**Re: Kiddie Academy Westside**  
**Project Address (need an address)**  
**Traffic Circulation Layout**  
Architect's Stamp 03-31-2020 (C12-D003A)

Based upon the information provided in your submittal received 06-12-2020, the above referenced plan cannot be approved for Building Permit until the following comments are addressed:

TRAFFIC CIRCULATION LAYOUT

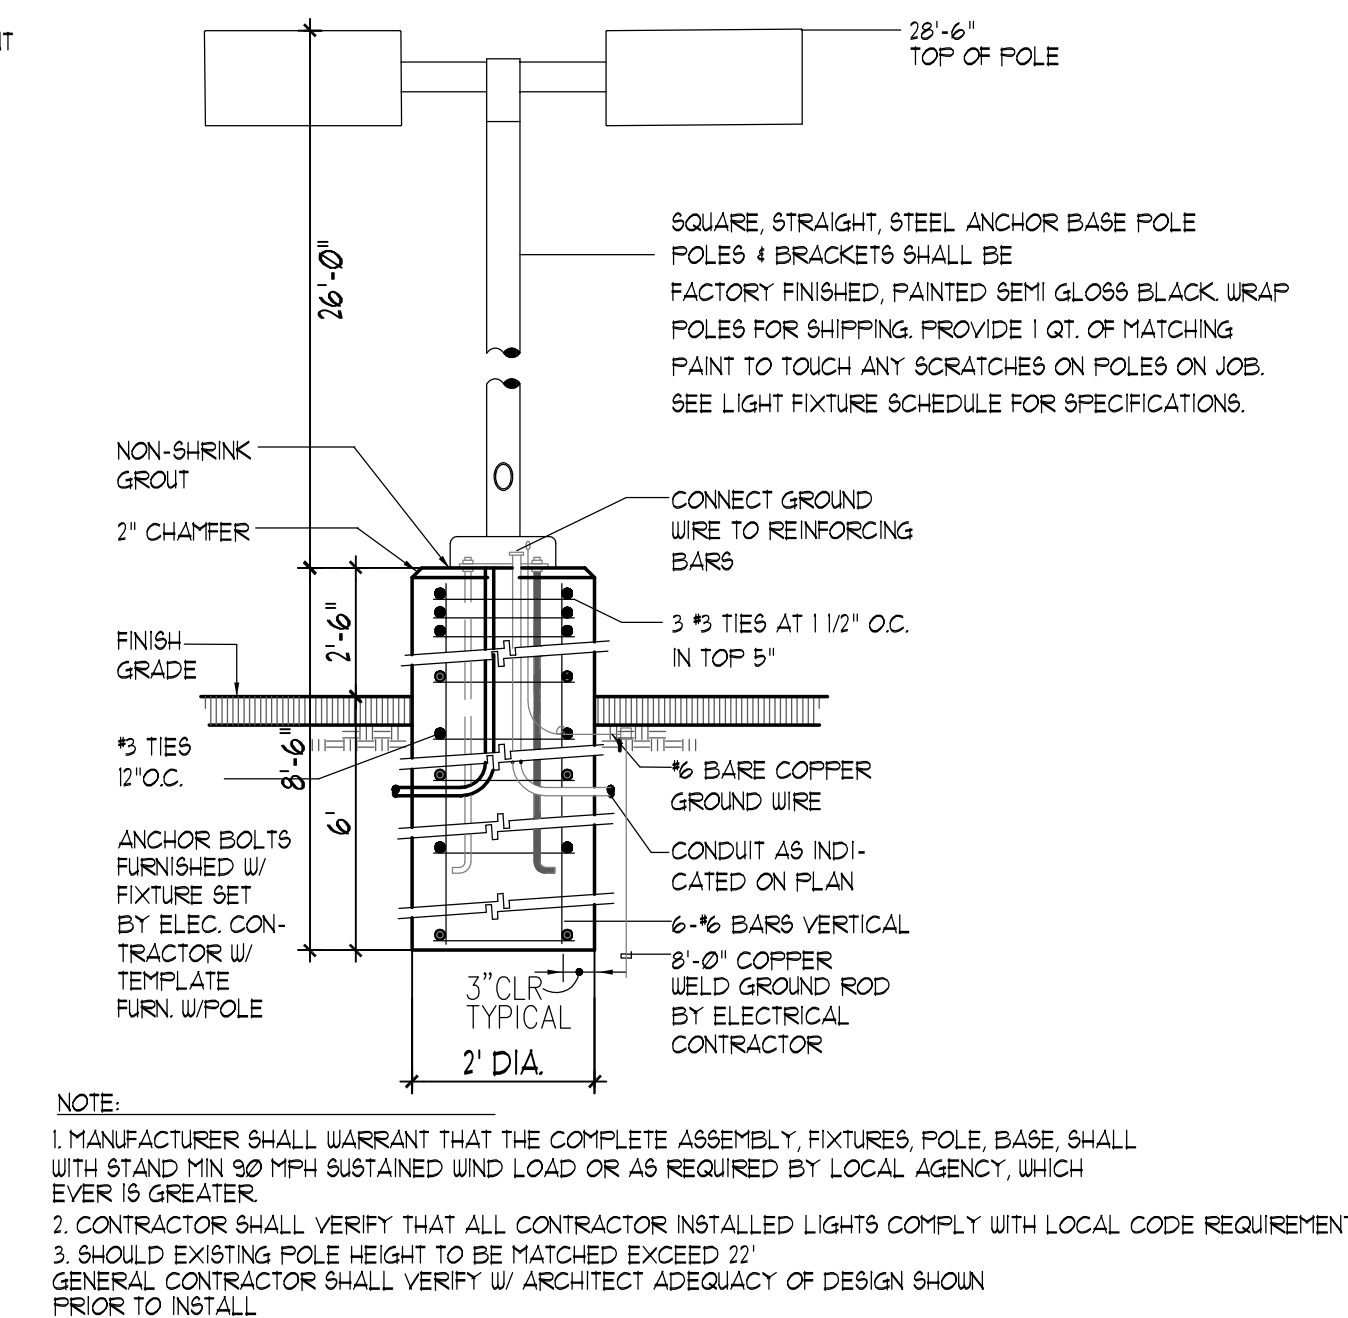
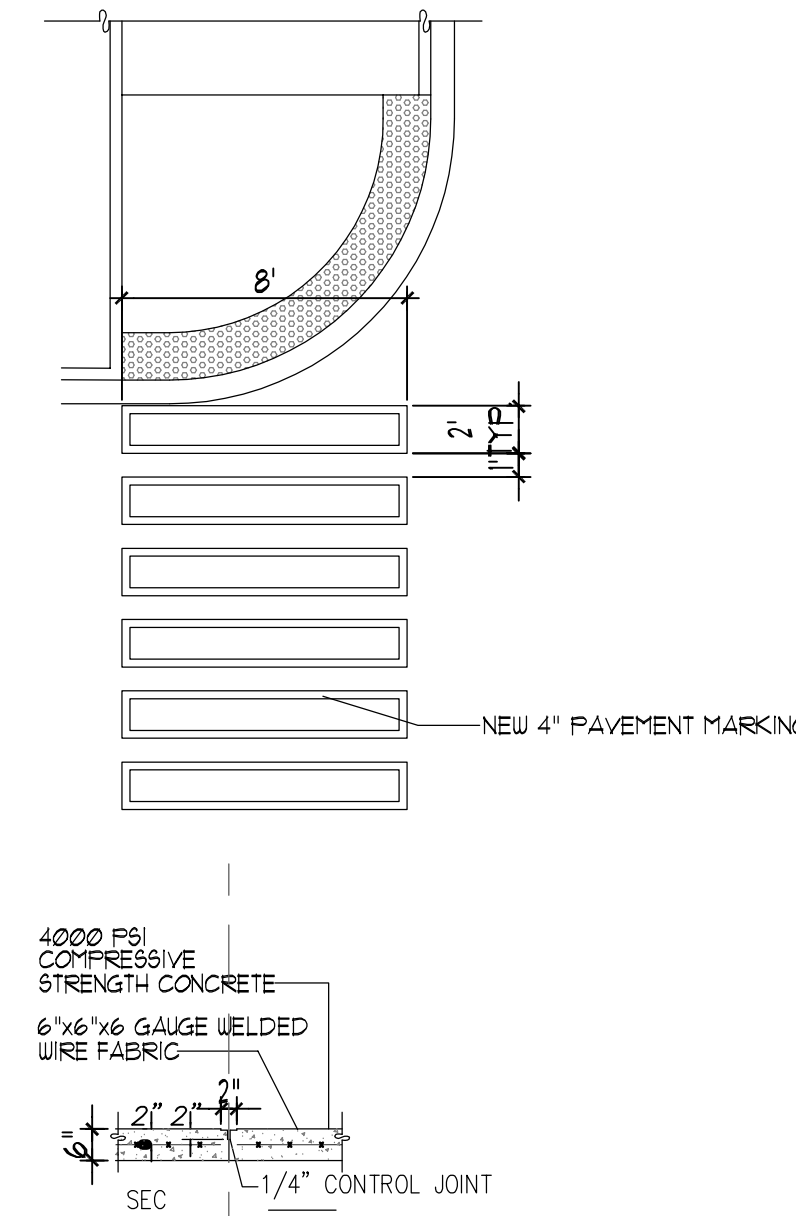
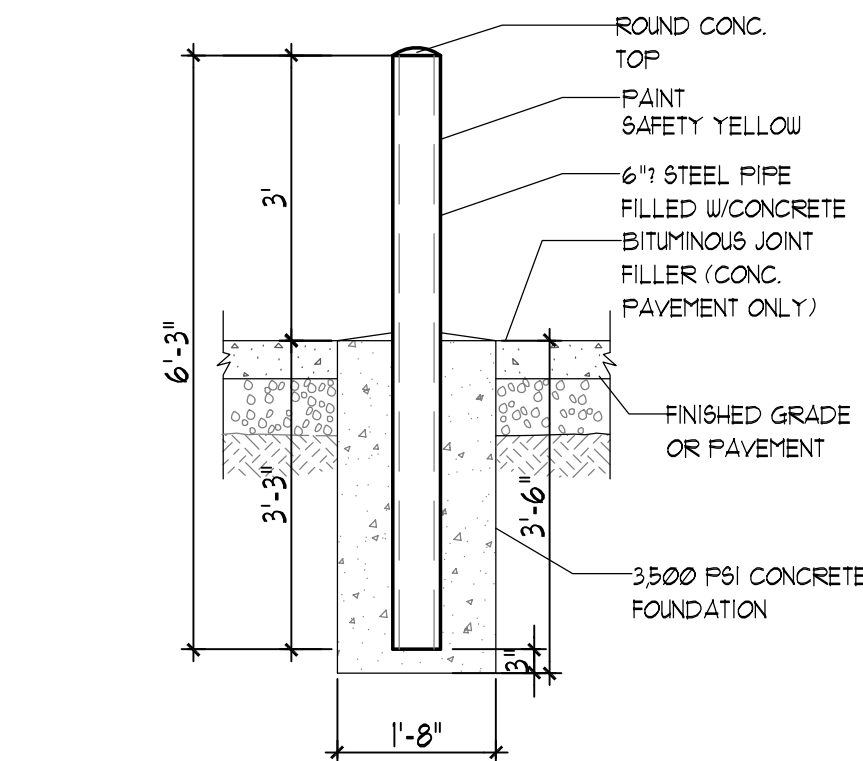
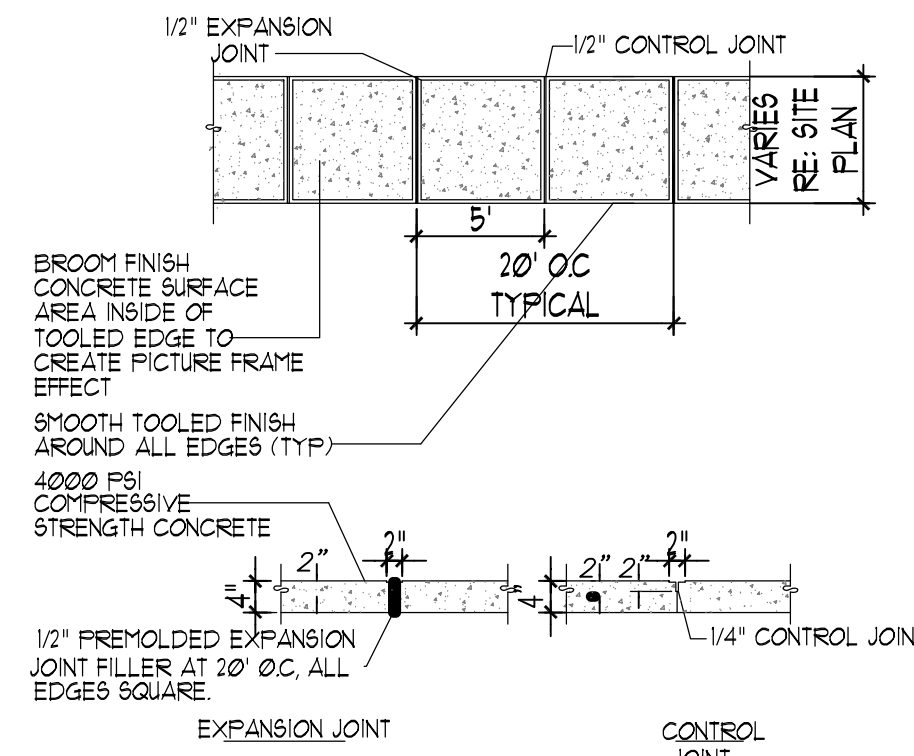
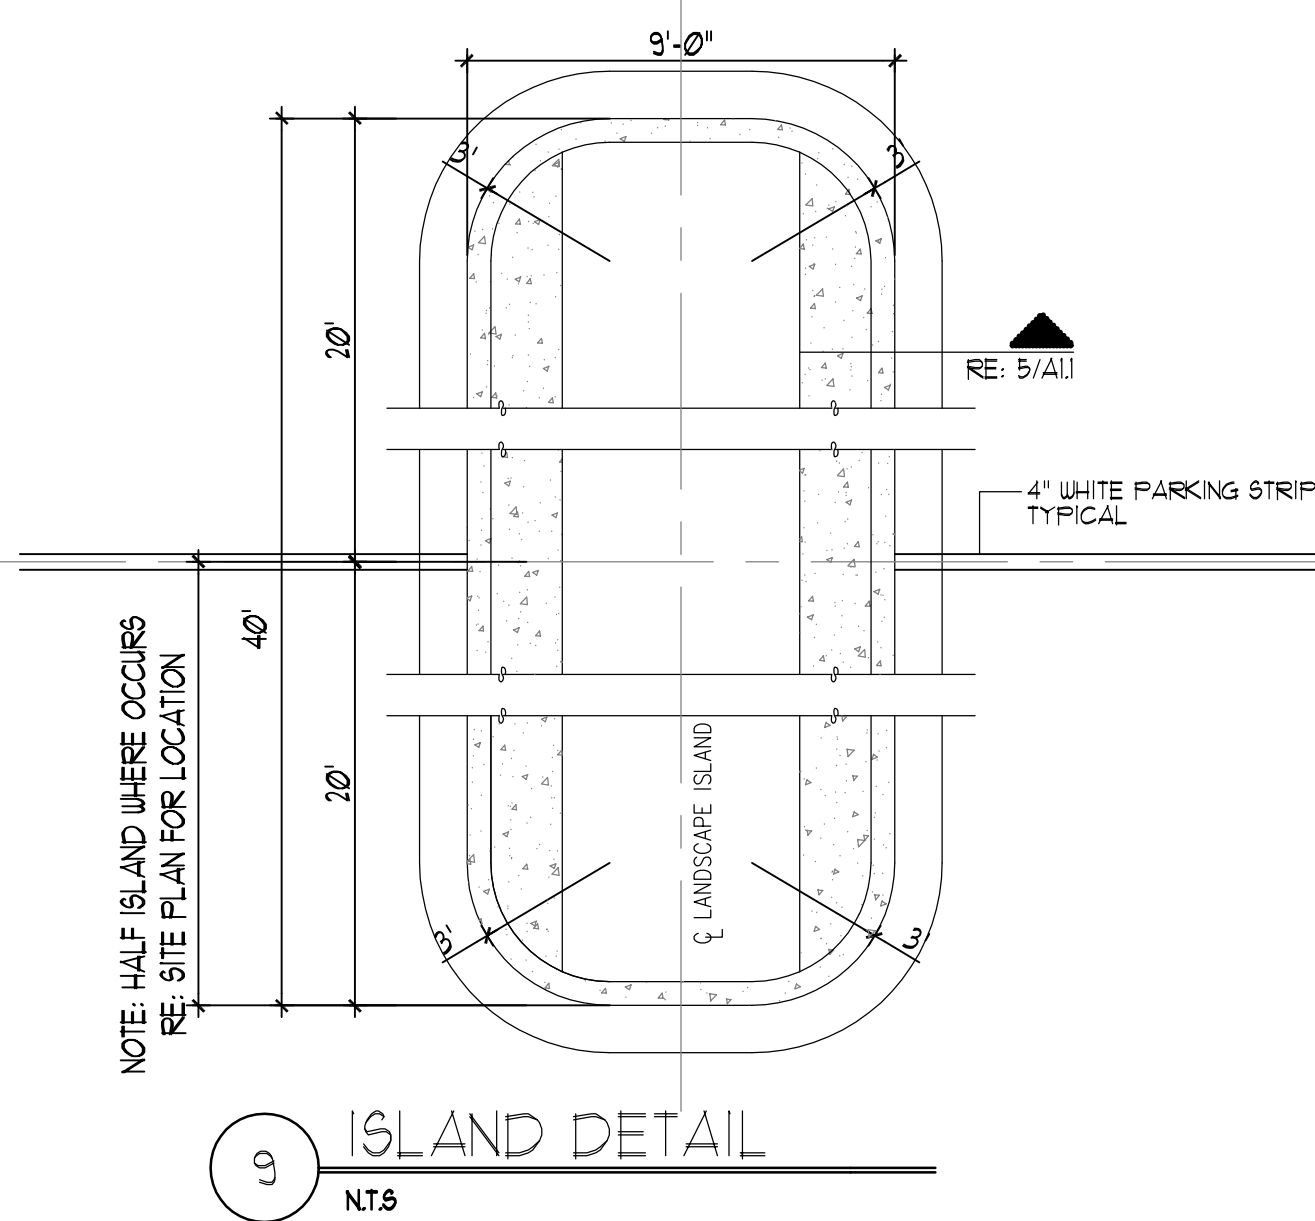
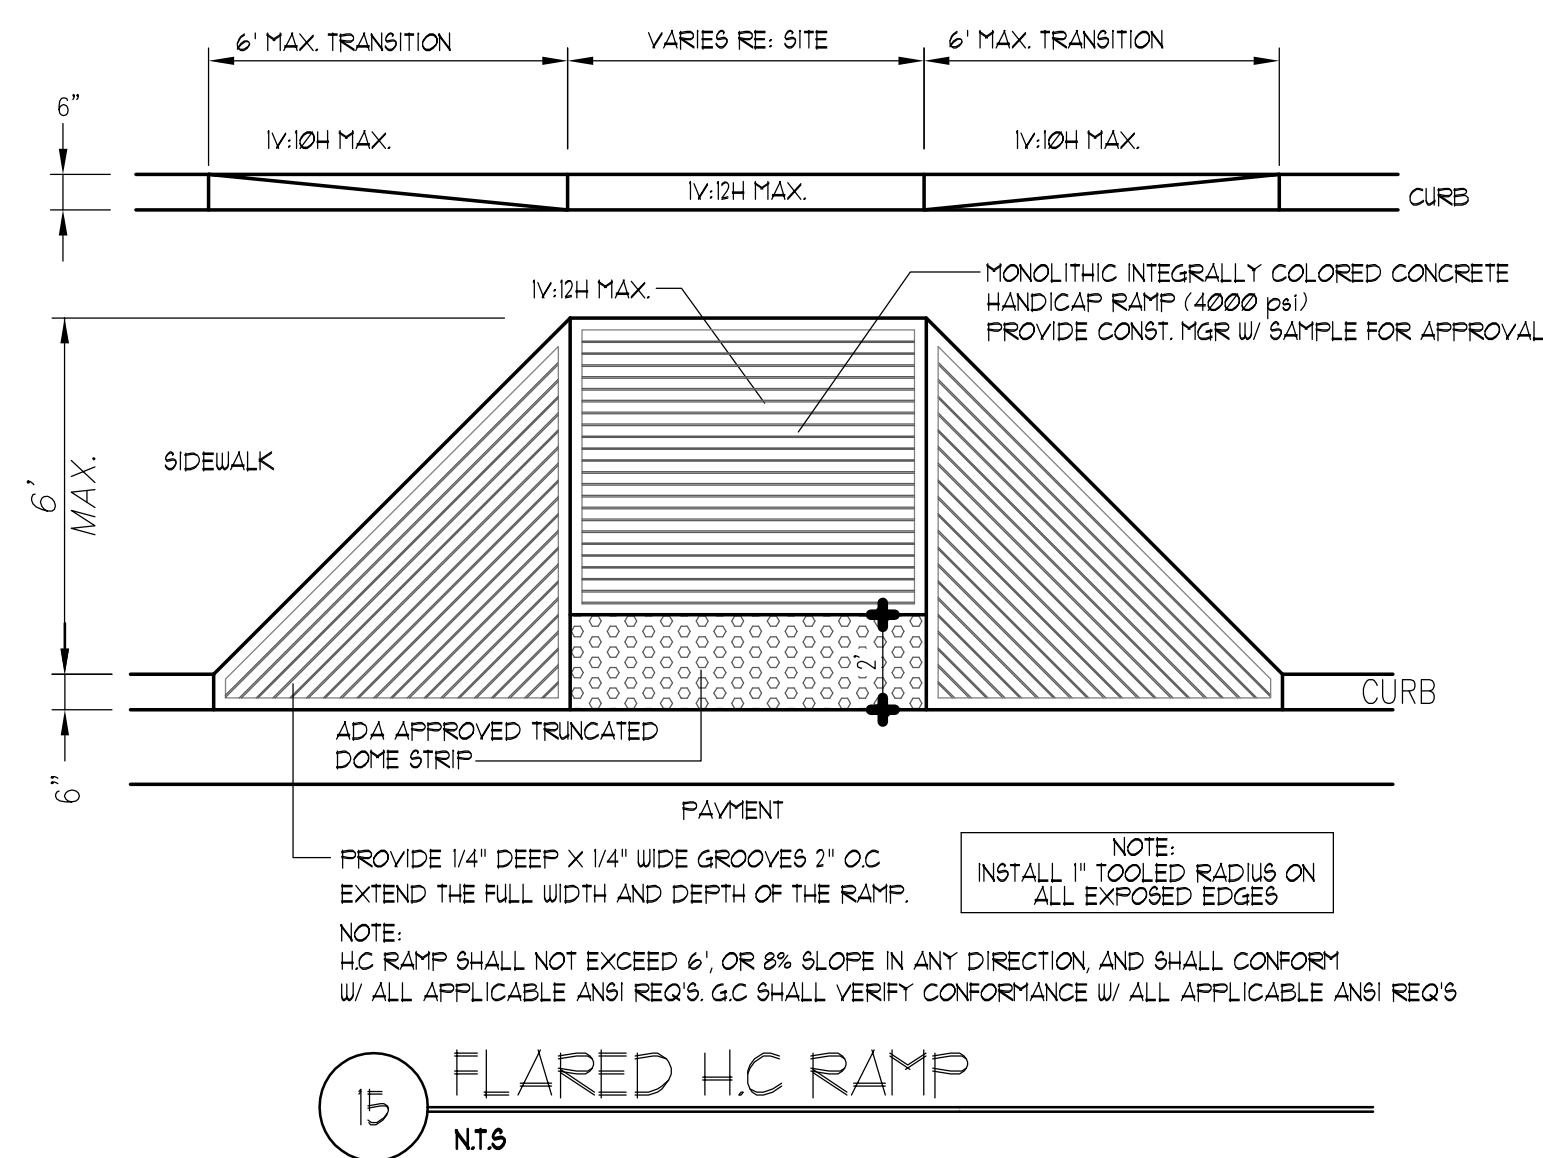
1. Proposed entrances fronting Paradise Blvd:
  - The Paradise Blvd median will need keyed notes 27 and 38 signage provided.
  - Label and provide standard C&G detail on west side of entrance

- Please label and dimension all existing infrastructure off the public streets. The sidewalk width will need to be shown on Paradise Blvd.
2. Identify all rights of way widths, medians widths and street widths on Paradise and Nunzio. Label each street with its appropriate names.

7. Per the IDO, a 6 ft. wide ADA accessible pedestrian pathway is required from the public sidewalk to the building entrances. What is the status of this pathway off Nunzio? Clarify this issue. **You need to address this comments.**

8. What is the compaction percentage of subgrade and base course on you proposed pavement design? **If the proposed roadway sections fall within City right-of-way, the need to be 95% compaction with a minimum R-value of 50. This needs to be included in you design.**

9. The following signs will be needed at Nunzio median: One Way sign (R6-1R, No left turn(R3-2). Please coordinate any required signage with Traffic Operations, Mahn Tran: 505-857-8689, **(Has this been coordinated???)** for the type of signage and the location of the installment. **Provide sign face details for both these signs on your detail sheet.**

10. Are you going to provide stop sign on your access road intersecting Paradise and Nunzio?
11. Keyed notes 27 and 38: Provide a sign face detail on you detail sheet.

12. The access road has a proposed centerline striping but no label as to the thickness and color of striping. A keyed note will be needed to identify this type of striping.

15. A street address is will need to be provided for this proposed project. **This prior comment needs to be addressed.**
16. Add a note stating "All broken or cracked sidewalk must be replaced with sidewalk and curb & gutter." A build note must be provided referring to the appropriate City Standard drawing. This prior /comment note needs to be added to plan.

13 BIKE RACK  
NTS

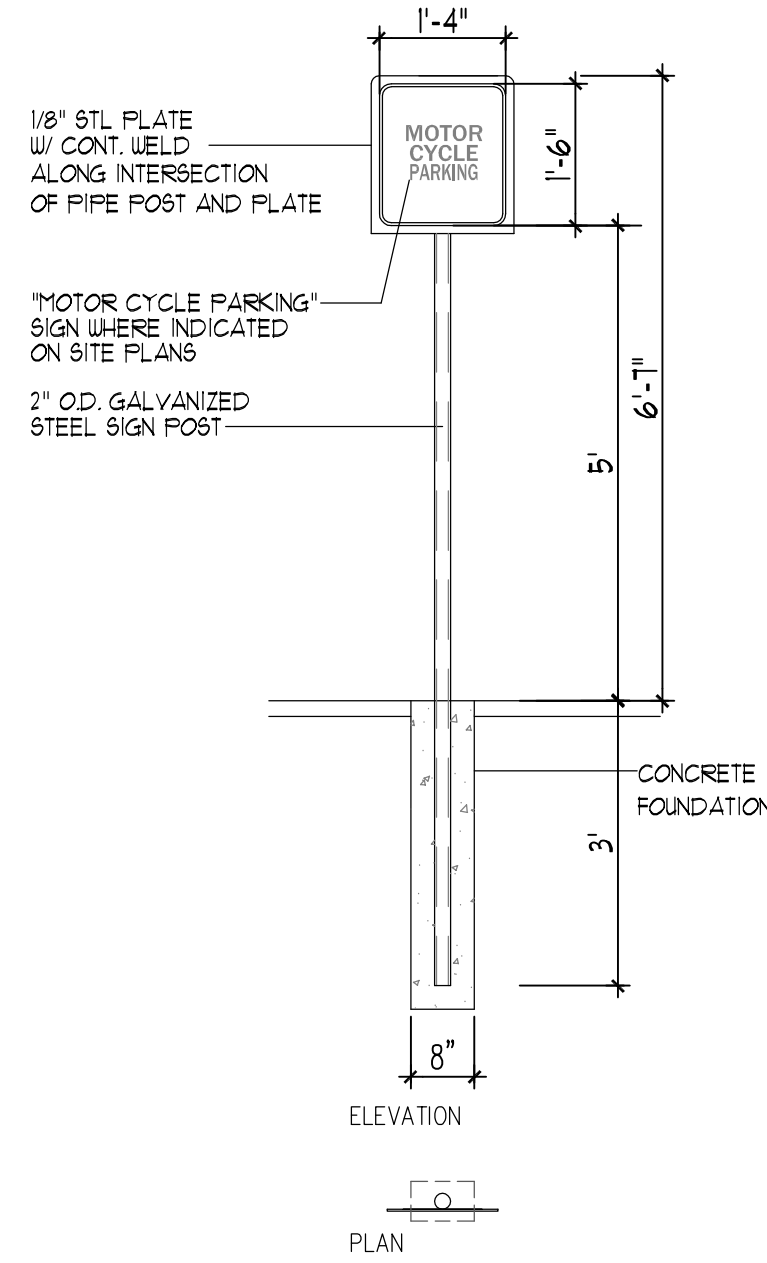
3. Include these notes on plans if you have not provided in detail sheets(Have these bike notes been incorporate into plans???):
  - a. The rack shall be a minimum 30 inches tall and 18 inches wide.

- b. The bicycle frame shall be supported horizontally at two or more places. Comb/toaster racks are not allowed.
  - c. The rack shall be designed to support the bicycle in an upright position. See the IDO for additional information.

- d. The rack allows varying bicycle frame sizes and styles to be attached.
  - e. The user is not required to lift the bicycle onto the bicycle rack.

- f. Each bicycle parking space is accessible without moving another bicycle.

4. Bicycle racks shall be sturdy and anchored to a concrete pad.
5. A 1-foot clear zone around the bicycle parking stall shall be provided.
6. Bicycle parking spaces shall be at least 6 feet long and 2 feet wide.
